**ADC Planning Consultation
Response from the Historic Buildings Adviser**

Application Number	R/56/12 & R/57/12/L
Address	Old Orchard House, Rustington
Description	Extend and convert garage. Resubmission of R/237/11.
Case Officer	Peter Cleveland
Site Visit	Previous

DRW NO 4 SCALE 1/50
PROPOSED ROOF PLAN

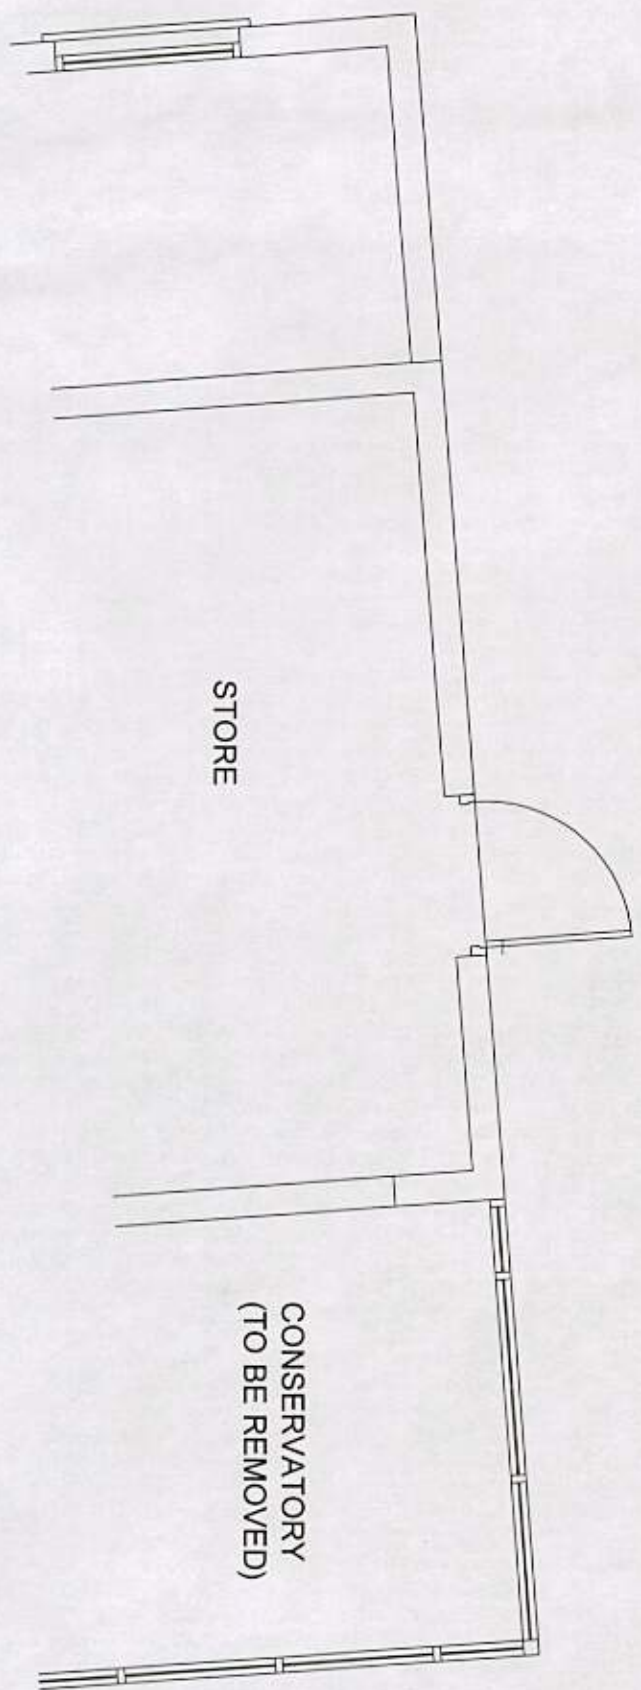
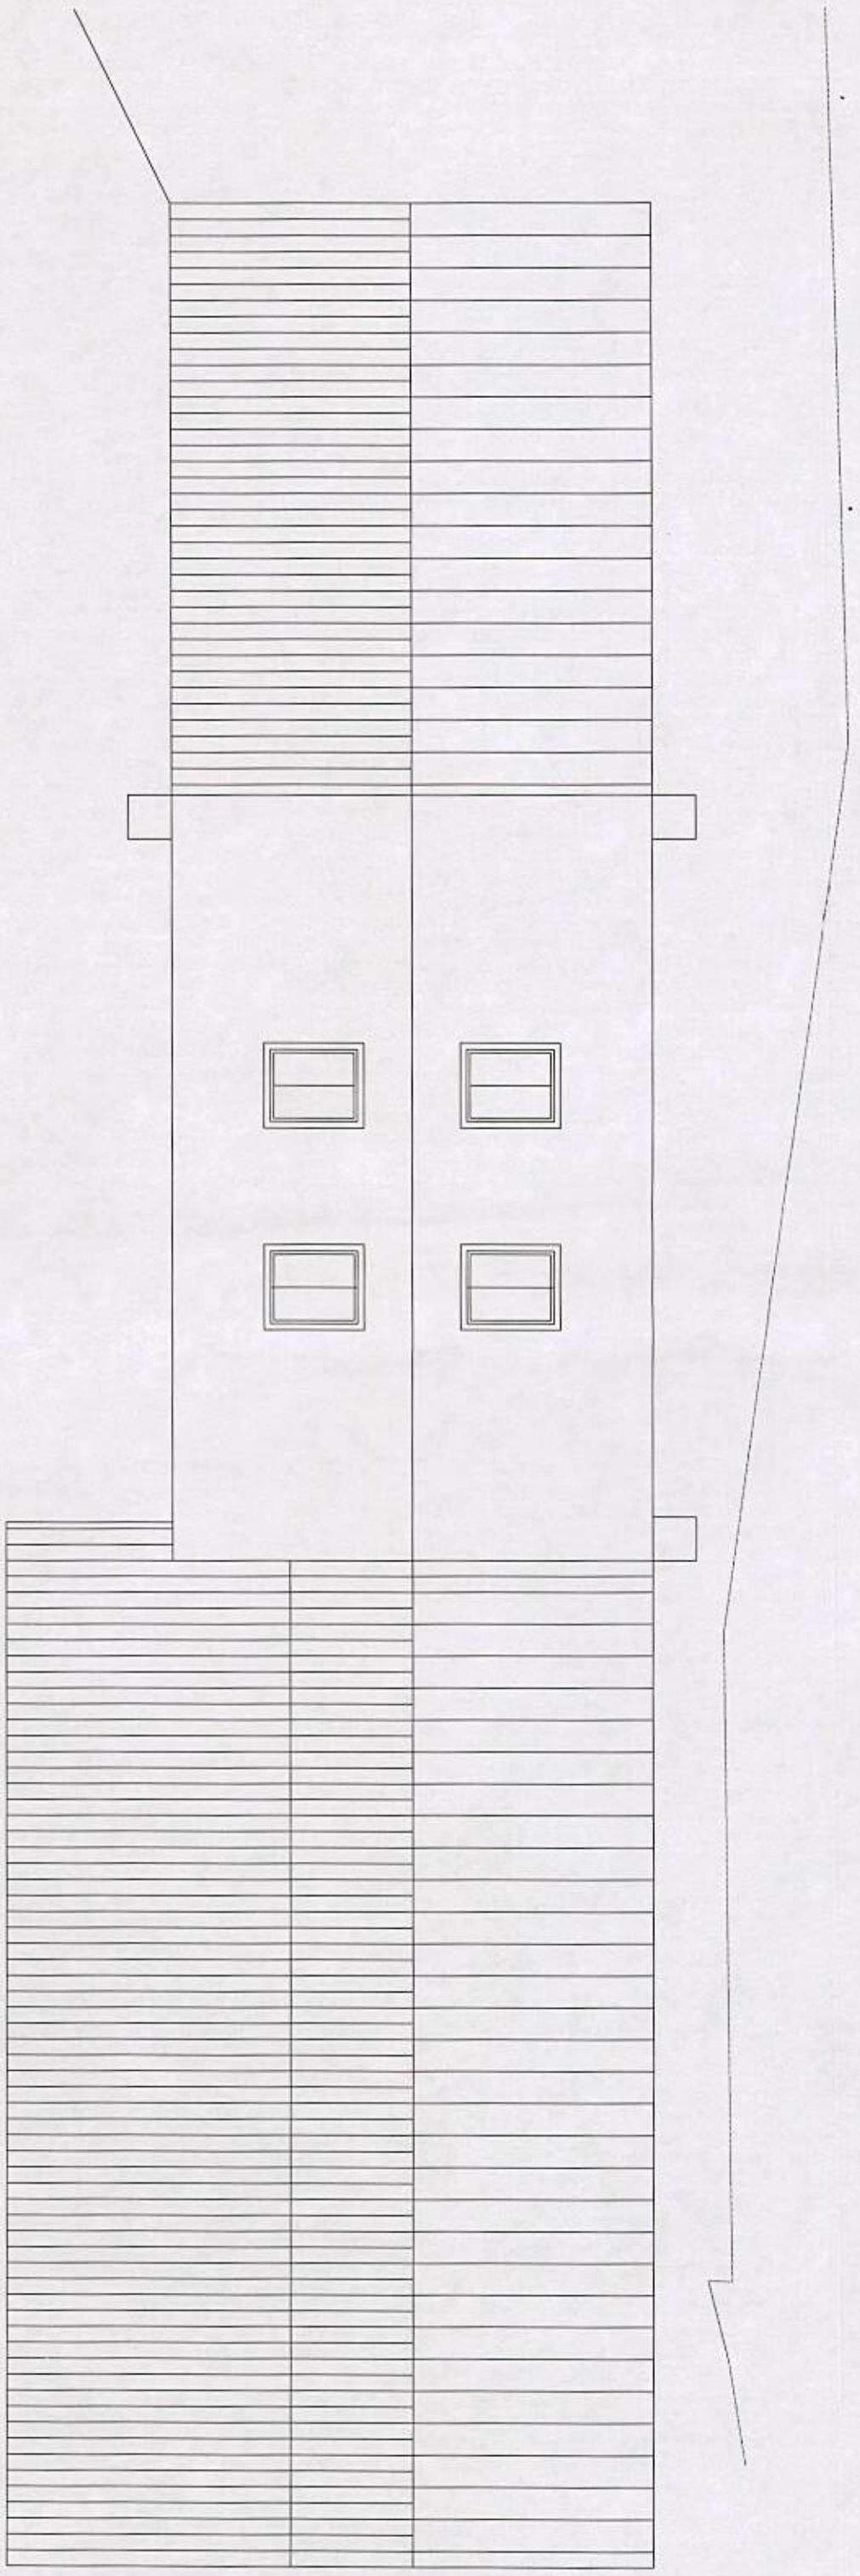
The principal concern is the new addition to the rear which in its attempt to achieve greater width, results in a rather incongruous roof form which is not sympathetic for an outbuilding to a listed building. Its overlapping with the existing garage also compounds the issue as it adds complexity to the roof scape to what is effectively a simple range of structures. The porch adds to this concern, but more problematically introduces a domestic quality to the building which should be avoided. Given the internal layout I would query the need for so much extra width, particularly in terms of justification.

DRW NO 6 SCALE 1/50
ELEVATIONS

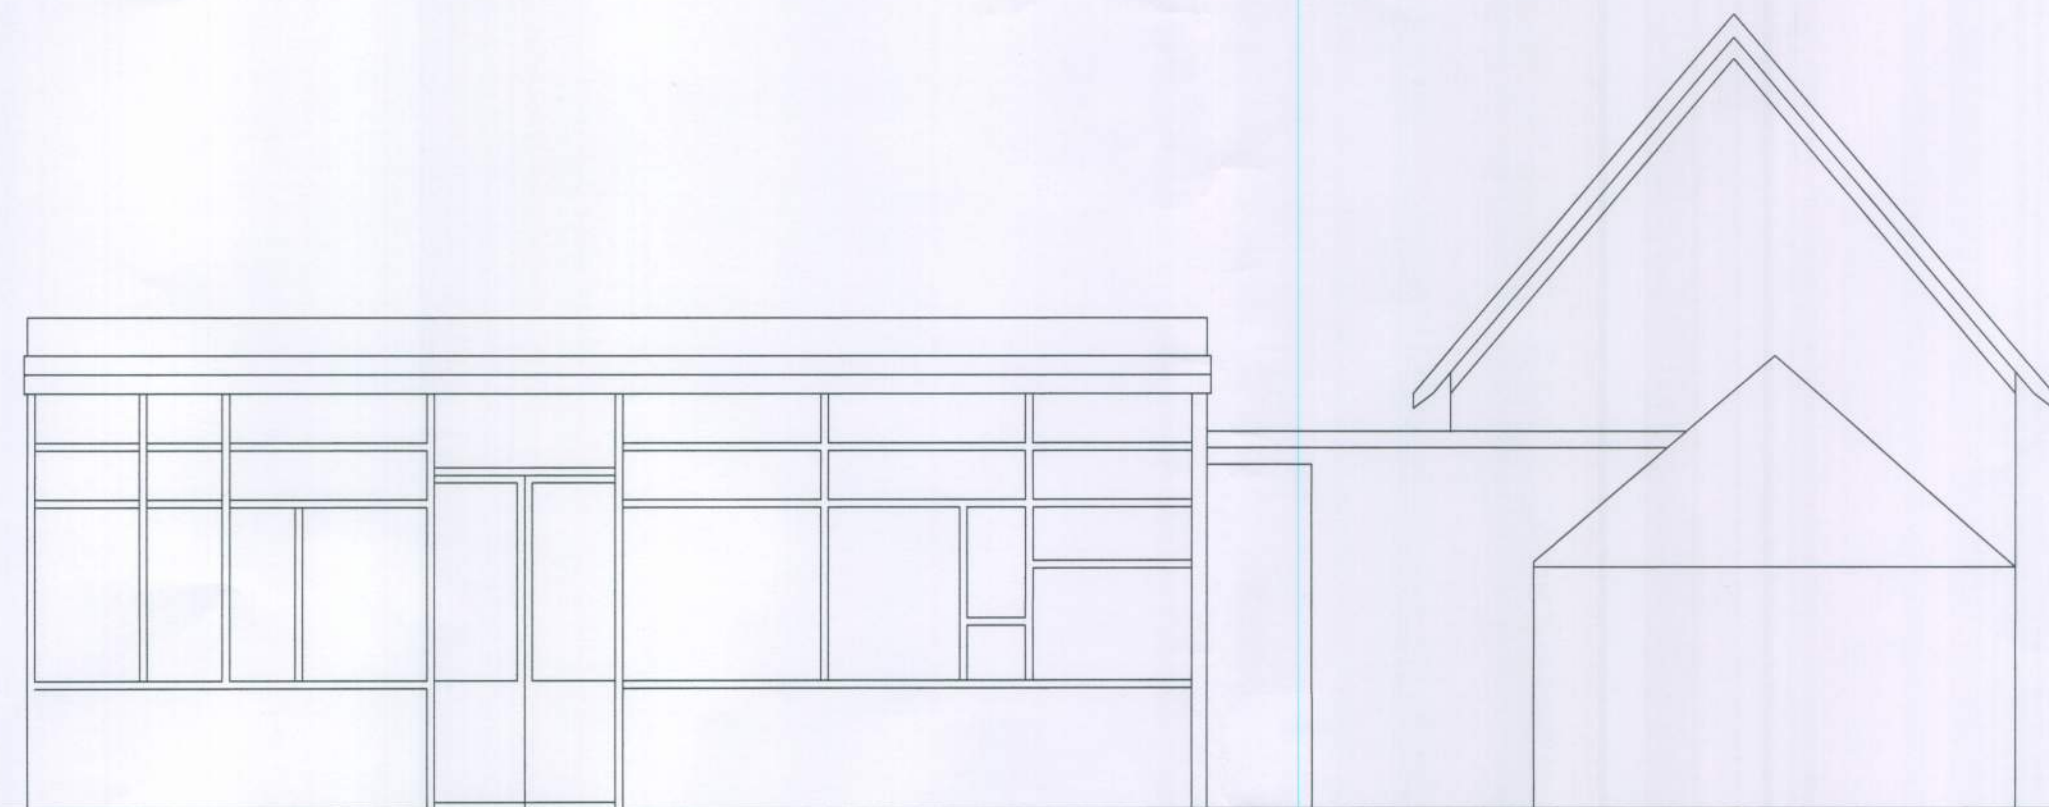
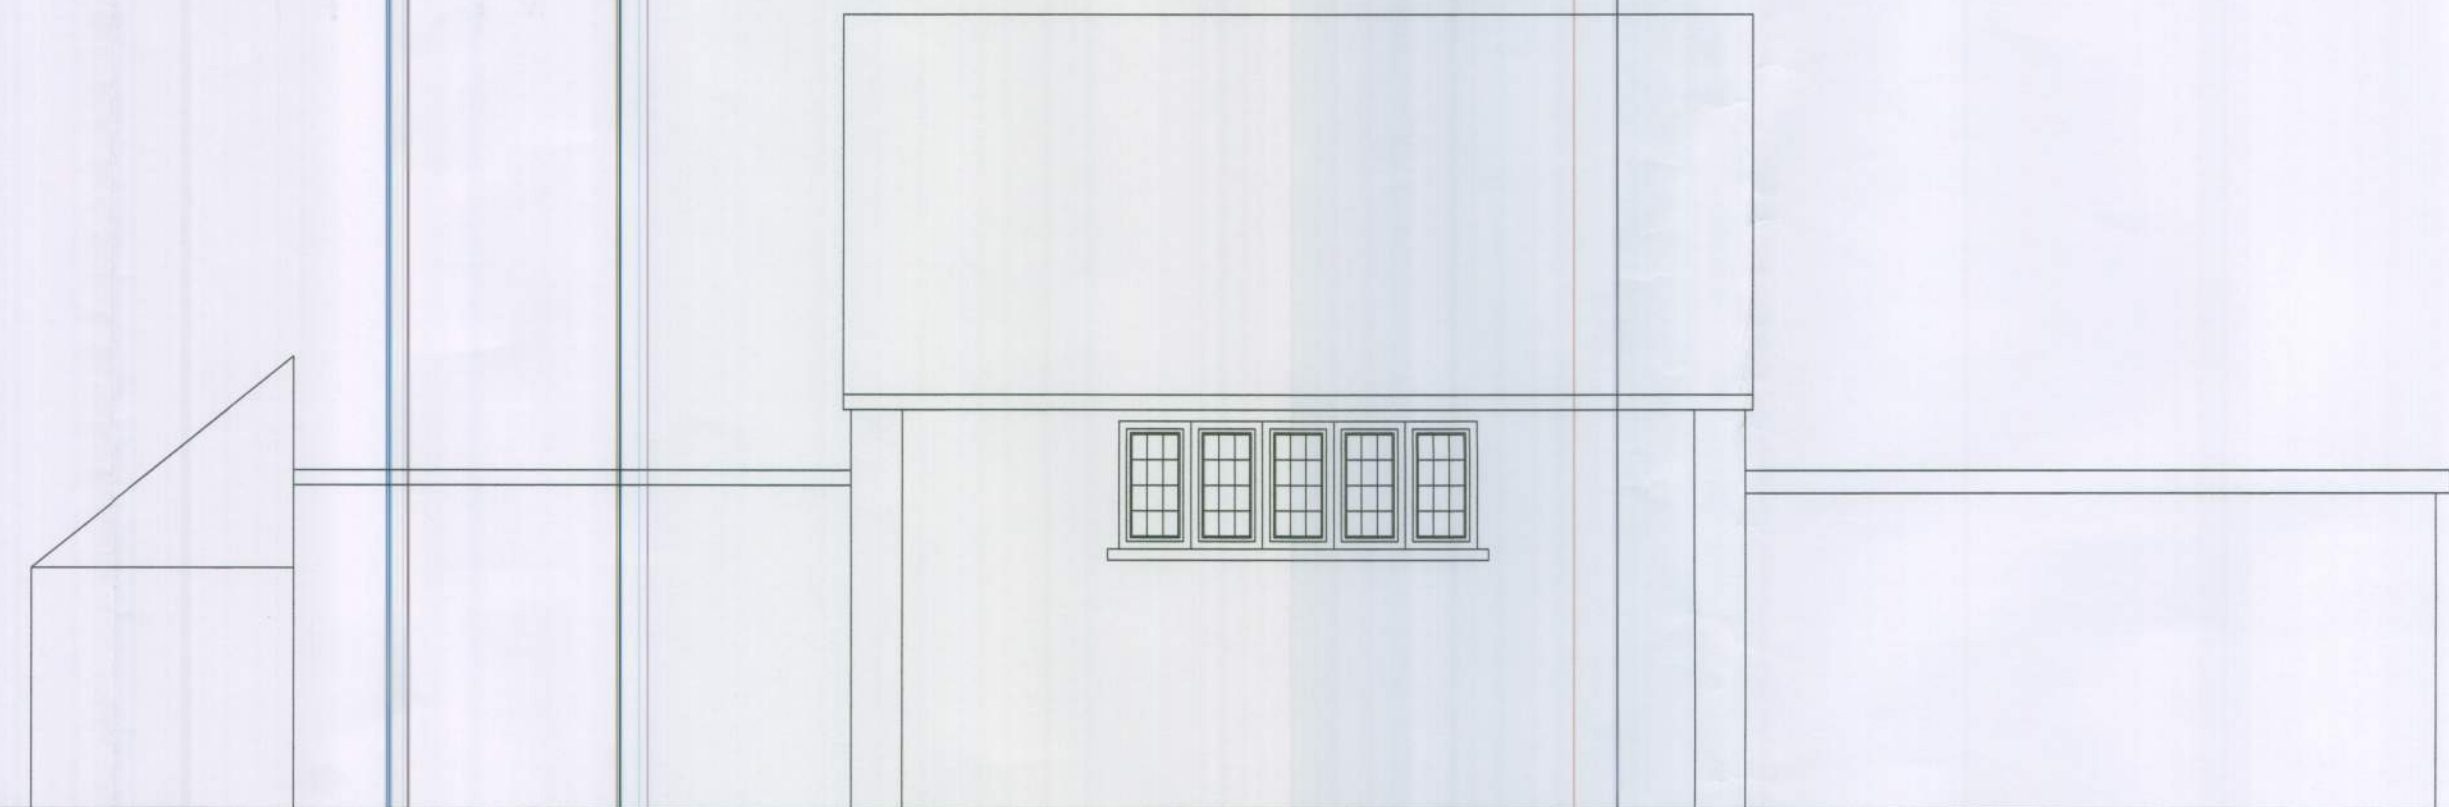
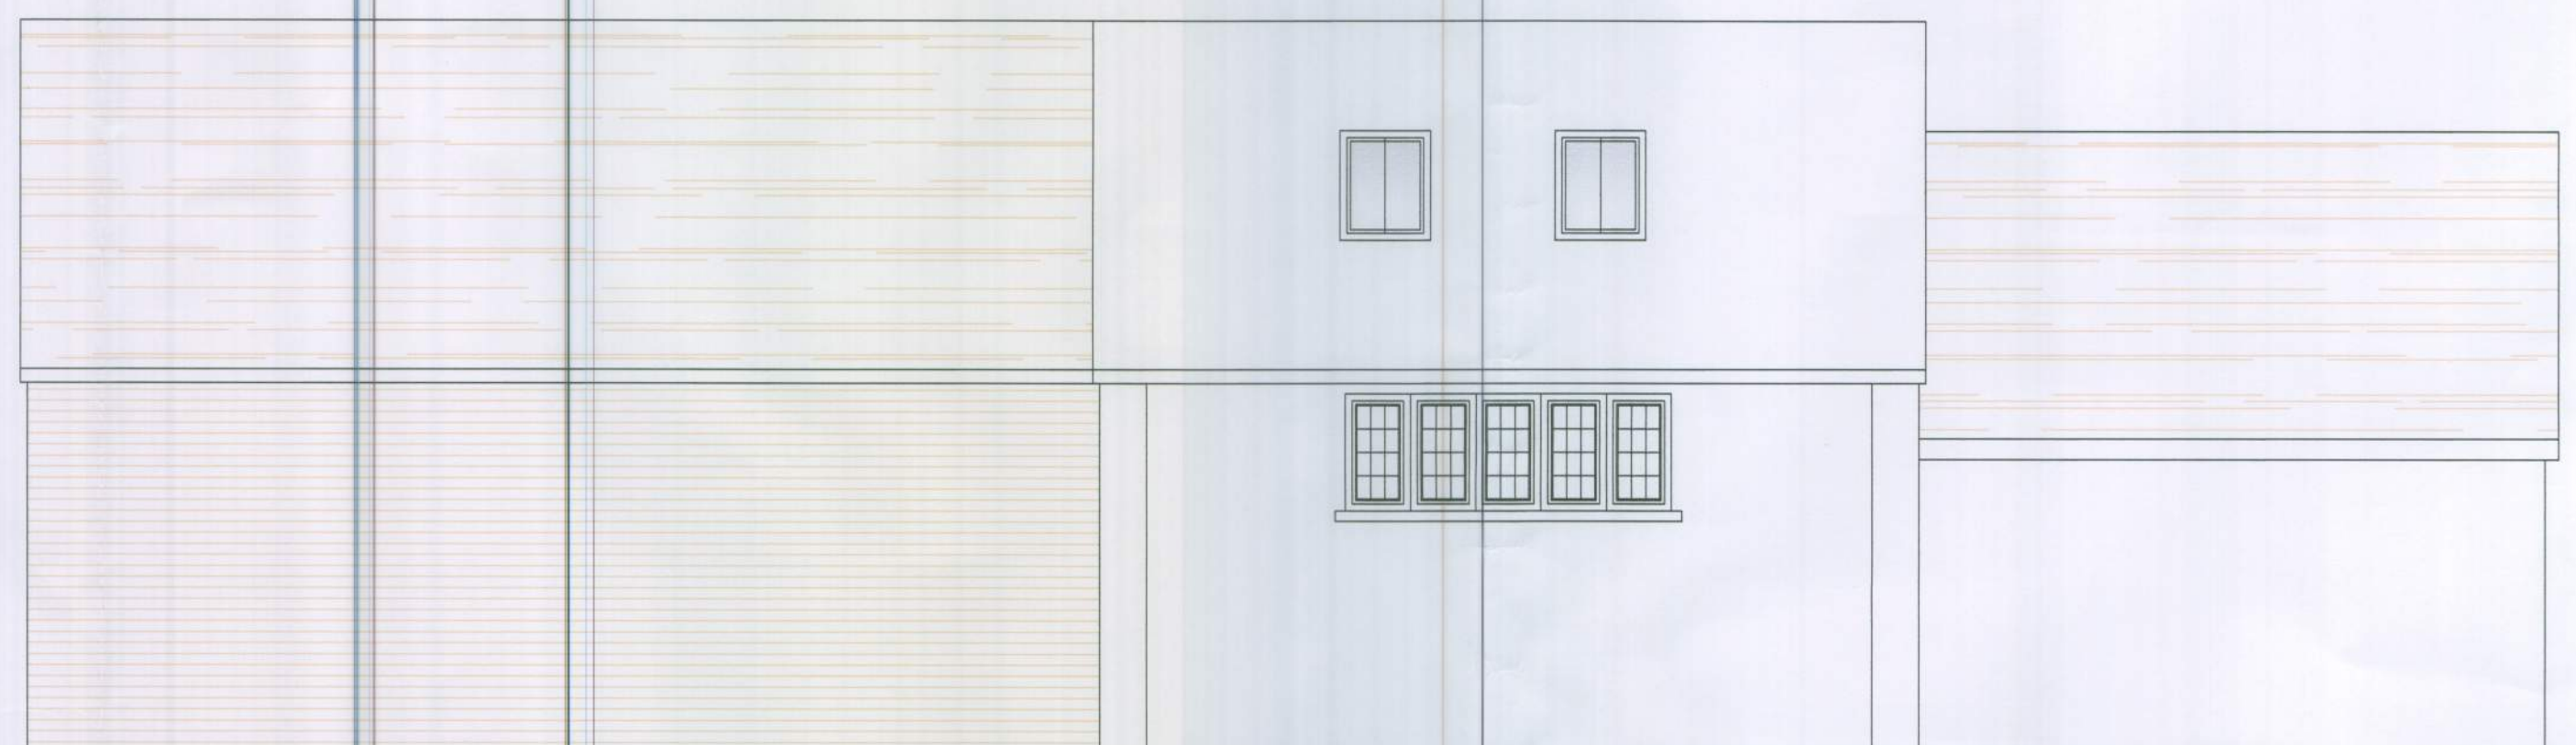
As well as the encroachment of the roof on the garage, the replacement of the existing window with a much larger aperture is also difficult to support. This again introduces a rather domestic character to what is a simple outbuilding. A further issue here is the justification for the change given that it opens onto a 'dressing area'. On the roof, the introduction of four roof lights would again appear excessive, especially given the small space that is being achieved within the roof space.
